Address: 10, WOODWARD COURT, MIRFIELD, WF14 0PY

Application number: 2025/93355	
What is the application for?:	Erection of 75 residential dwellings with associated landscaping, open space, hi
Address of the site or building:	Land off, Woodward Court, Mirfield, WF14 0PY
Postcode:	LS15 8ZB

Type of comment: An objection	
Do you wish your comments to be published on the website anonymously?	No

DRAINAGE APPRAISAL

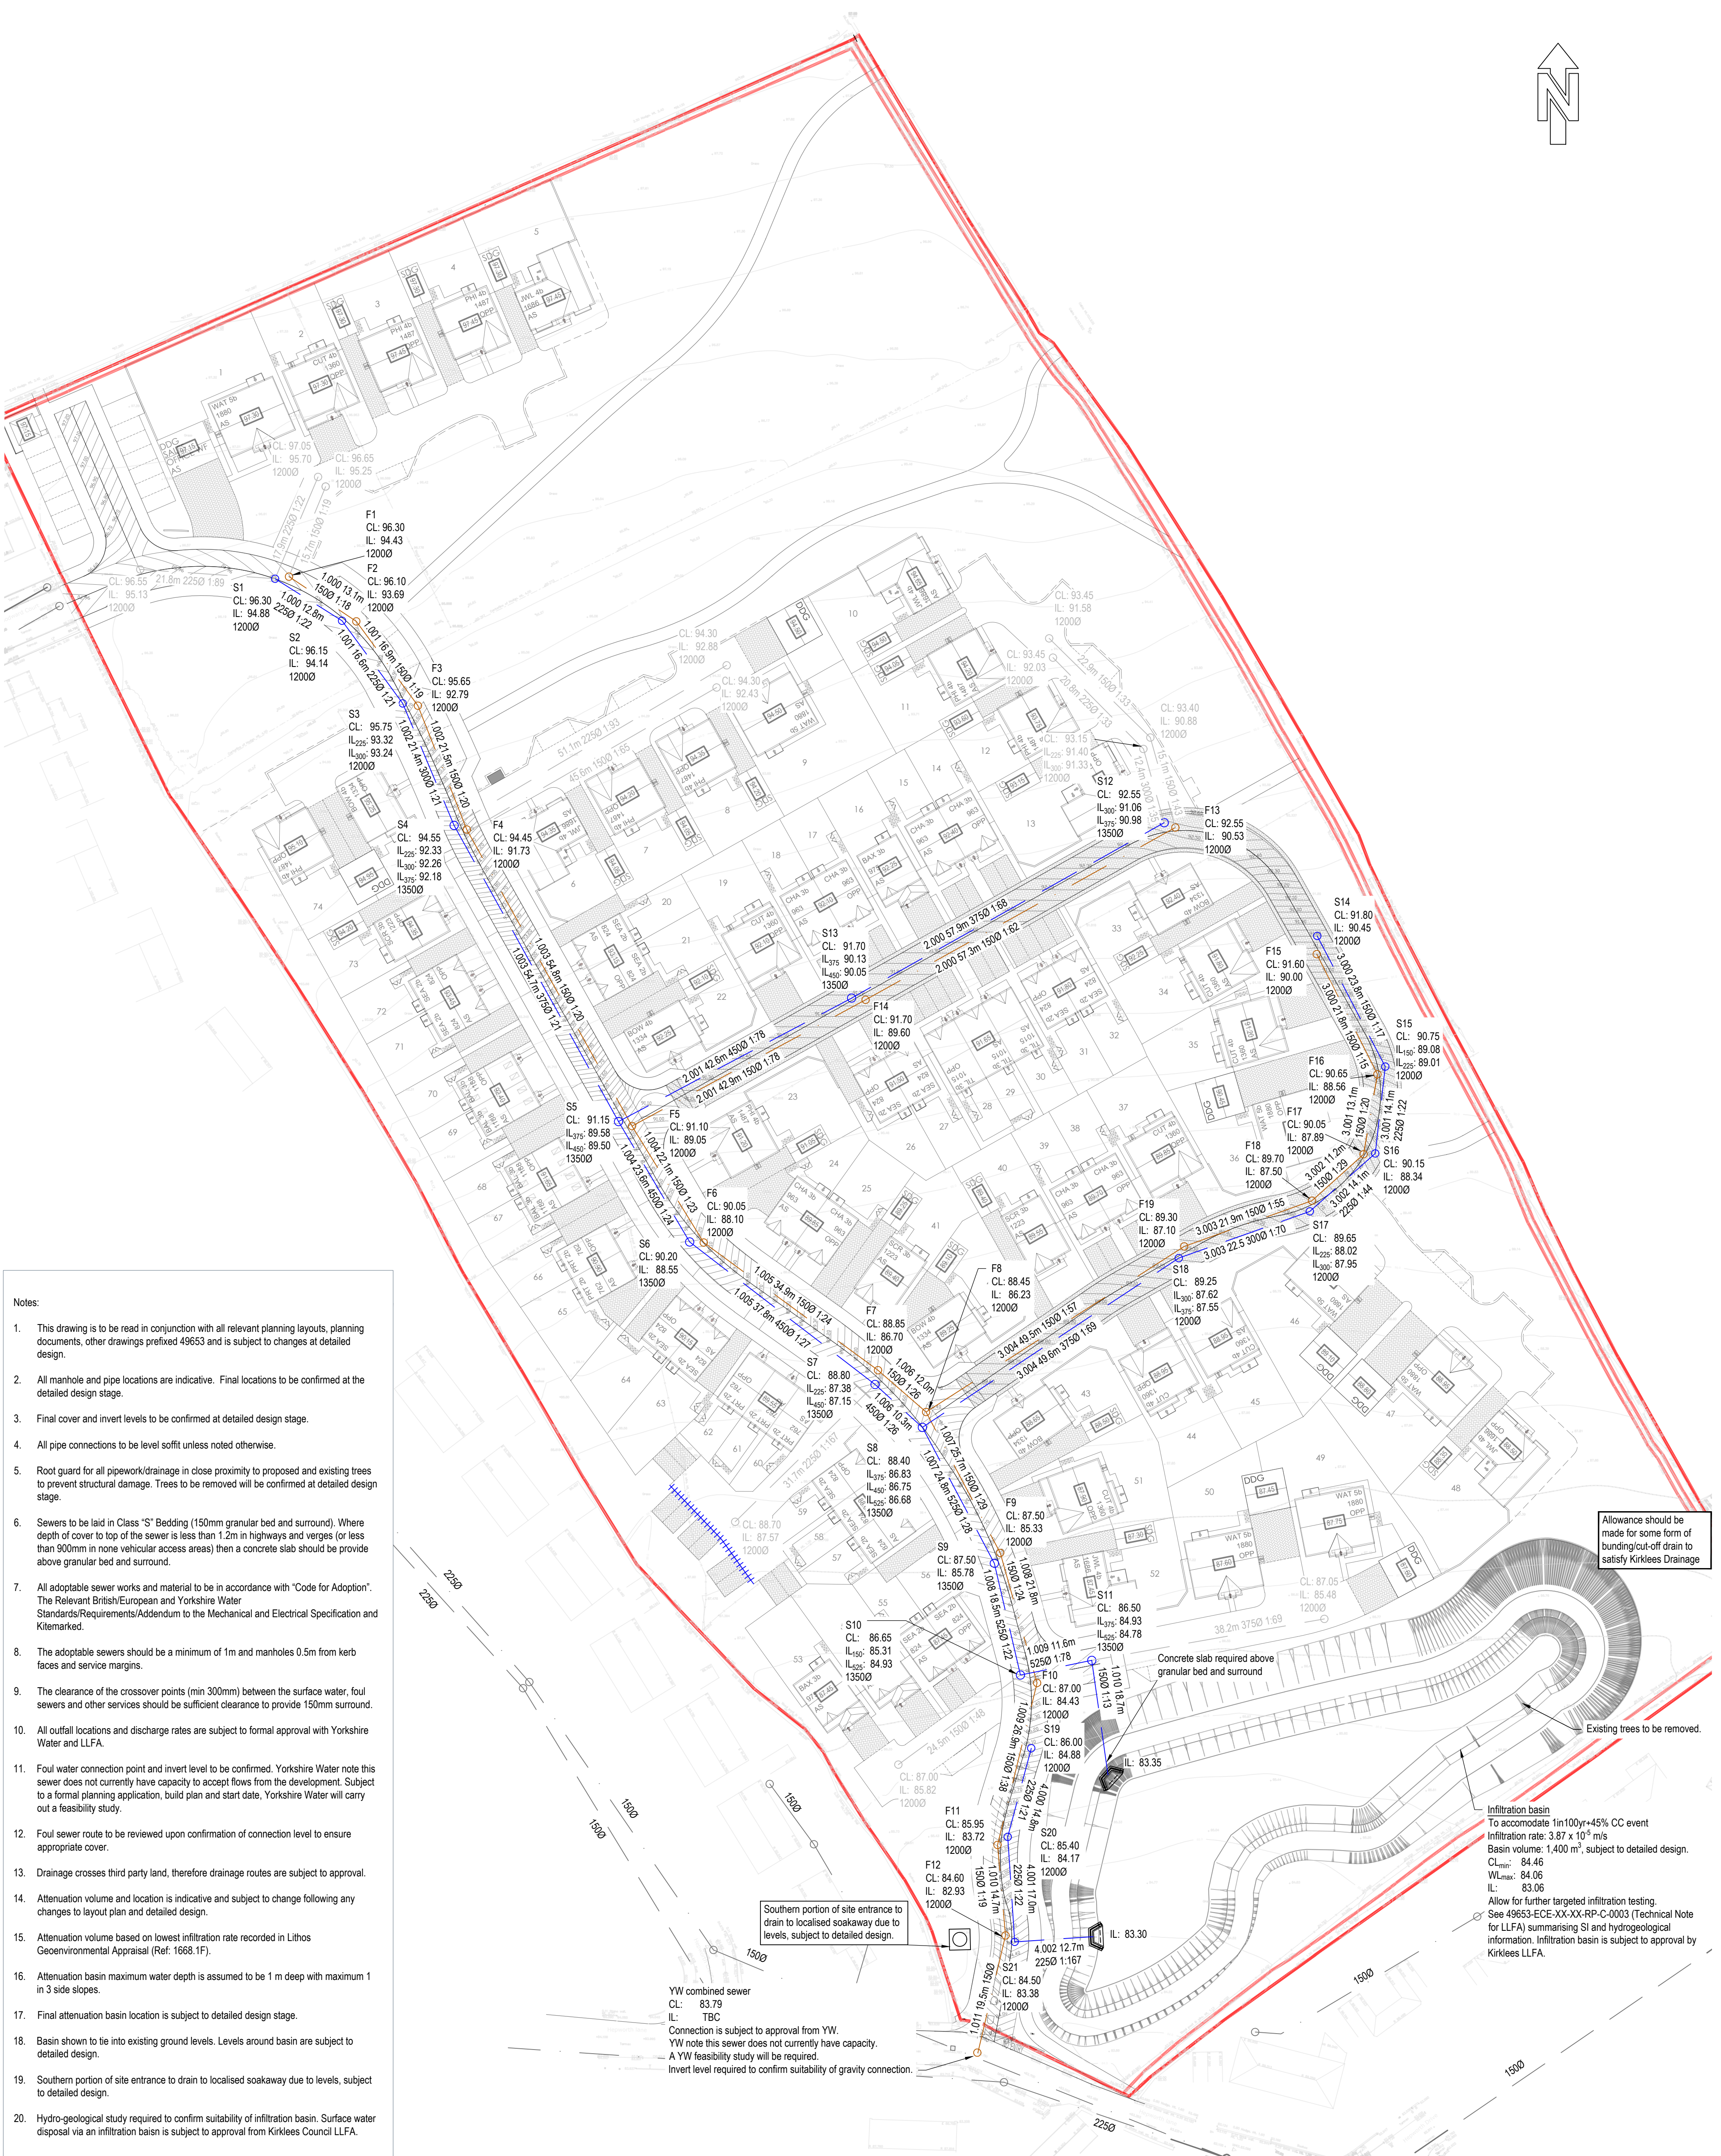
The conclusions of the report state that foul drainage will be taken to the 225 diameter pipe within Hepworth Lane and whilst it acknowledges that this would be subject to formal approval by Yorkshire Water, the correspondence within Appendix 4 from Yorkshire Water states that this sewer does not have sufficient capacity for the additional flows created by the site. Whilst there is no doubt an engineering solution to this it potentially involves significant upgrade work which would considerably inconvenience local residents.

For surface water, the Drainage Assessment Report rightly identifies the need for sustainable drainage solutions however it is unclear how these will be achieved. The Drainage Assessment Report concludes that surface water flows will be directed to an infiltration basin at the south of the site. However text elsewhere in the report casts doubt on an infiltration solution being appropriate in areas of disused mineworking where the subsurface drainage paths are difficult to predict and therefore there is a risk of flows surfacing outside of the development site with unknown consequences for existing properties.

The Design and Access Statement refers to the use of an Attenuation Basin which is a very different solution to an Infiltration Basin which clearly demonstrates that the overall design is not coordinated. Attenuation Basins can be seen at many locations along the Highway Network and are often unsightly engineering solutions where vegetation does not grow due to the presence of salt laden water or the inevitable wetting and drying of the surface.

The design of any water body in a residential environment must consider the public safety implications. There have been too many tragic events in recent years for the consequences of unsupervised children gaining access to water bodies to not require robust mitigation measures possibly in the form of heavy palisade type fencing.

Taken together the outstanding issues around the drainage mean that an integrated solution has not yet been developed. Presenting the sustainable drainage solution as a landscaped public amenity as described in the Design and Access Statement is a long way removed from the potential solution which could be a heavily fenced unsightly, muddy pool. This would be wholly inappropriate in this residential environment and sufficient grounds for refusing planning permission.
